File reference	TR020002
Status	Final
Author	The Planning Inspectorate
Date	2 November 2017
Meeting with	RiverOak Strategic Partners (RSP)
Venue	Temple Quay House
Attendees	The Planning Inspectorate Gareth Leigh – Infrastructure Planning Lead Richard Hunt – Senior EIA and Land Rights Advisor Nicola Mathiason – Lawyer Richard Price – Case Manager Louise Evans - Case Officer The Applicant Angus Walker (BDB Law) Alex Hallatt (BDB Law) Tony Freudmann (RSP) Niall Lawlor (RSP) George Yerrall (RSP) Rob Grinnell (RSP) Angela Schembri (RSP) Colin Smith (CBRE)
Meeting objectives	Review of the Planning Inspectorate’s comments on the draft application documents
Circulation	All

Manston Airport

Draft documents review

The following tables comprise the comments made by the Planning Inspectorate about the form and content of the suite of draft application documents offered by the Applicant (RiverOak Strategic Partners Ltd) in October 2017.

Manston Road

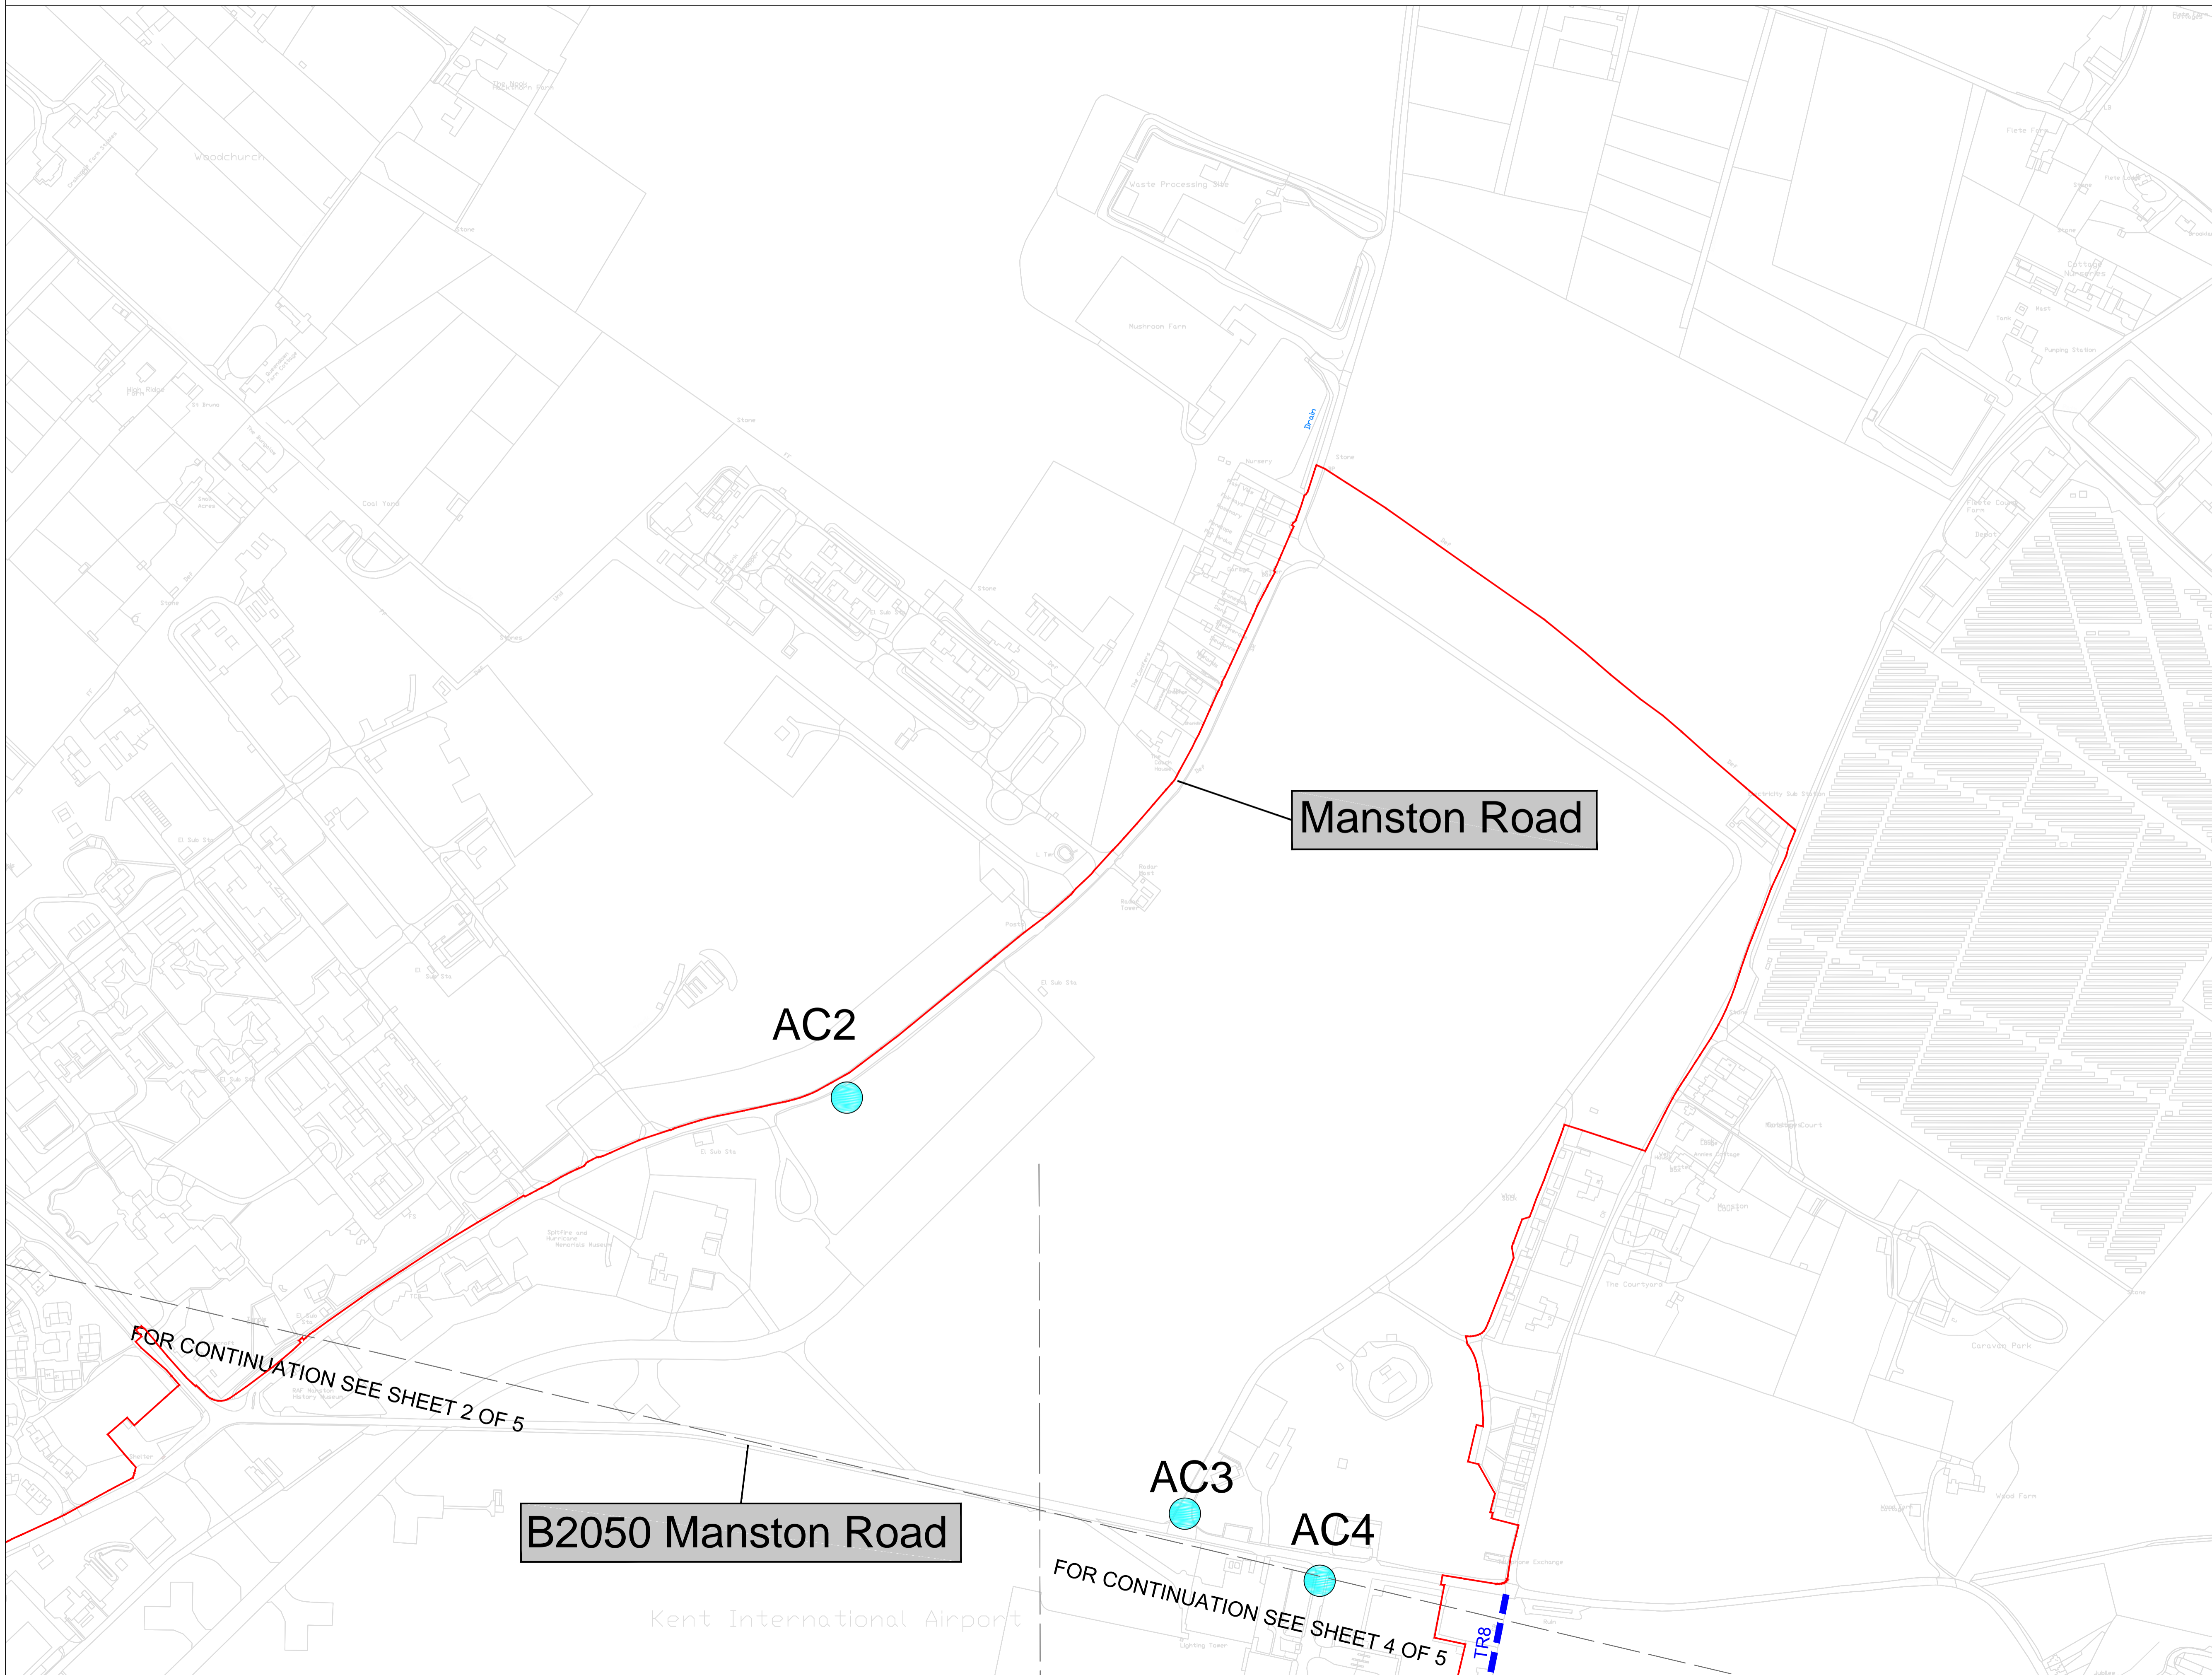
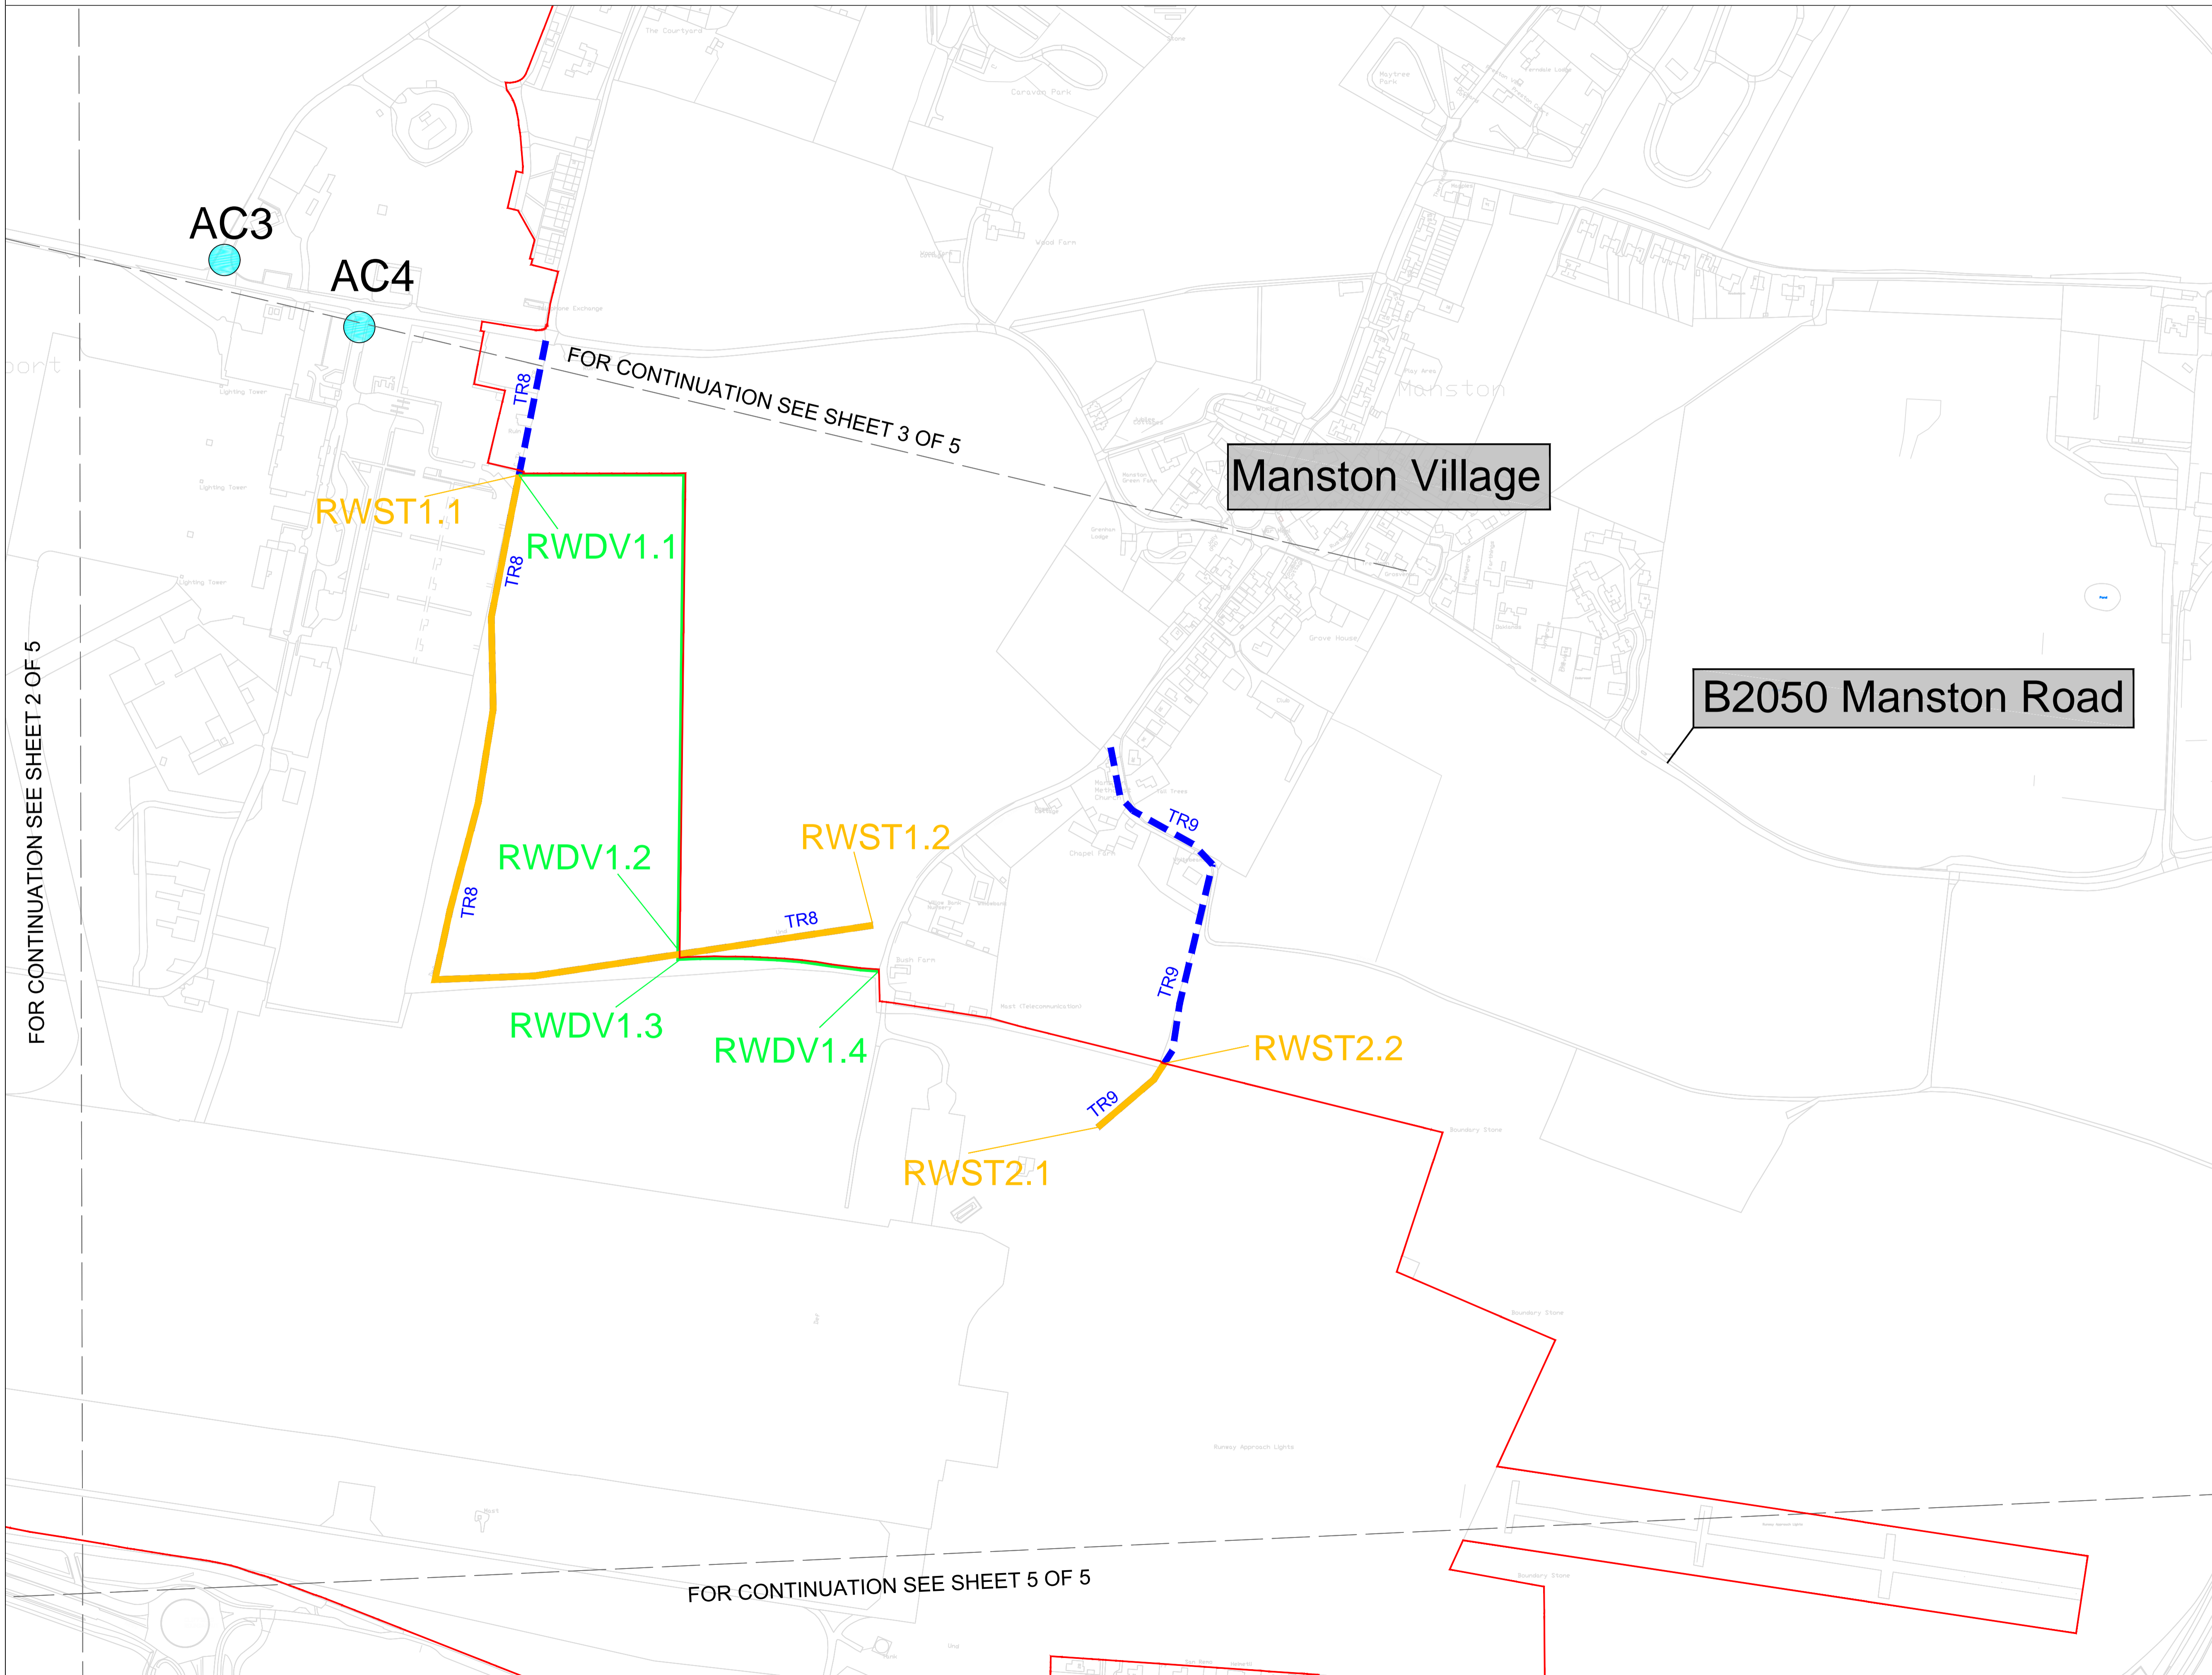
Article 10	<p>A10(1): These streets referred to should be identified on the streets, rights of way and access plan at Schedule 9</p>

and words included in this article that reference that plan; similarly with the diverted/ altered streets.
Article 11	Could the streets referred to be listed in a Schedule?
Article 13	The words " <i>with the consent of the relevant planning authority and after consultation with the highway authority</i> " should be included.
Article 14	A14(1): This should state it is for the purposes of the construction of the authorised development. A14(2): Explanation and justification needed for this. A14(5): Further explanation about implications of this needed to assist Examining Authority. A14(6): Justification for this wording needed as the usual wording included in this article is " <i>at any time prior to the part of the authorised development to which it relates being brought into operational use</i> ".
Article 15	A15(6): This provision prevents the discharge of gravel, soil, other solid substances, oil or matter in suspension. It makes no reference to matter in solution, which given that antifreeze is the main chemical discharge is a potential gap. However, the provision does make reference to Environmental Permit requirements which are likely to address this. It also makes reference to 'reasonably practicable' twice. A15(8)(b): Should the reference to the Water Resources Act 1991 be replaced by a reference to the Environmental Permitting (England and Wales) Regulations 2016?
